PLANNING APPLICATION 2026/90110

client	MR I HELEINE		
project	NEW DWELLING LAND ADJACENT TO 497 PENISTONE ROAD SHELLEY, HUDDERSFIELD, HD8 8HY		
drawing	DETAILED SITE PLAN		
revision	notes	date	drawn
A	BIN STORAGE INCREASED	03.26	MG
scale :	1:50 AT A1	01.26	MG
project no.	drawing no.	revision	
2460	02	A

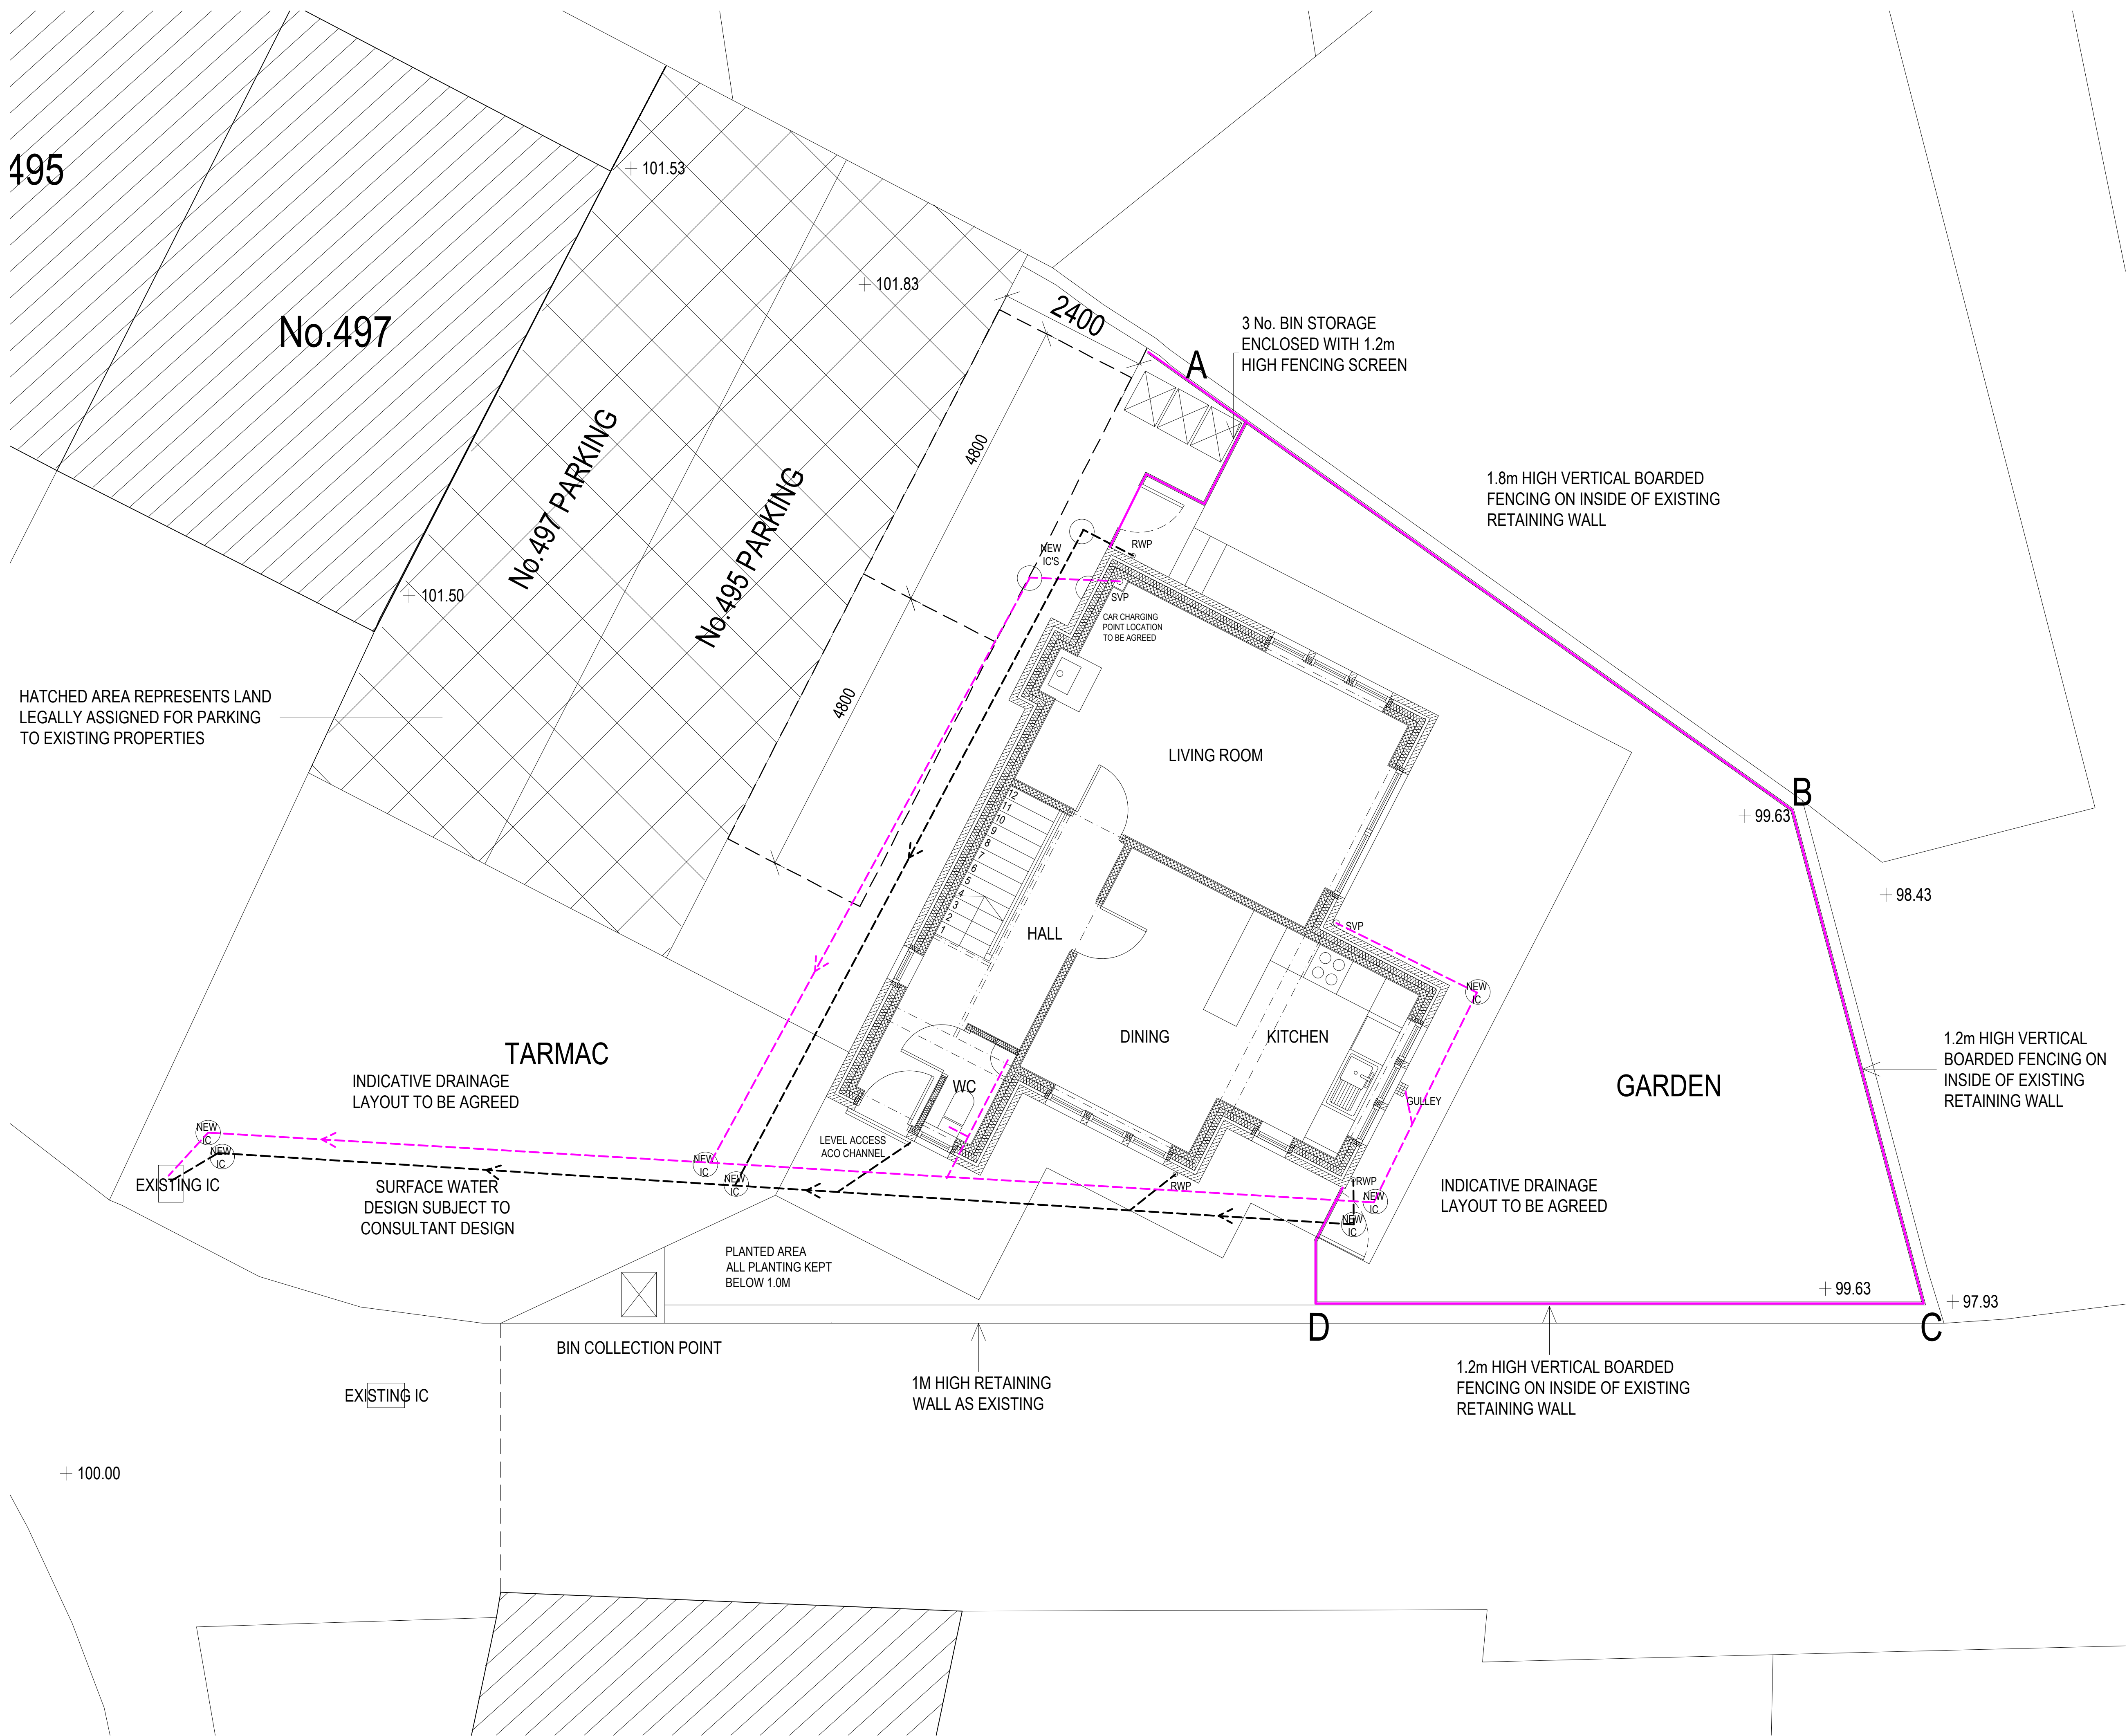
What will be the height of the new house in relation to Nos. 497 and 499?

The windows on the Northeast face will overlook the garden of No. 499 and the house will dramatically impact natural light to No. 499 through the afternoon and evening. Both these issues will impact the quiet enjoyment of No. 499 and its garden.

How will the ground water be captured so as not to gather further down the lane and run down the drive of no. 507?

The fence height of 1.8m from A to B will give a height of 1.8m on the 499 side of the boundary wall. I believe the wall between 497A and 499 is a joint boundary.

Will the dry stone wall be made safe between A and B?
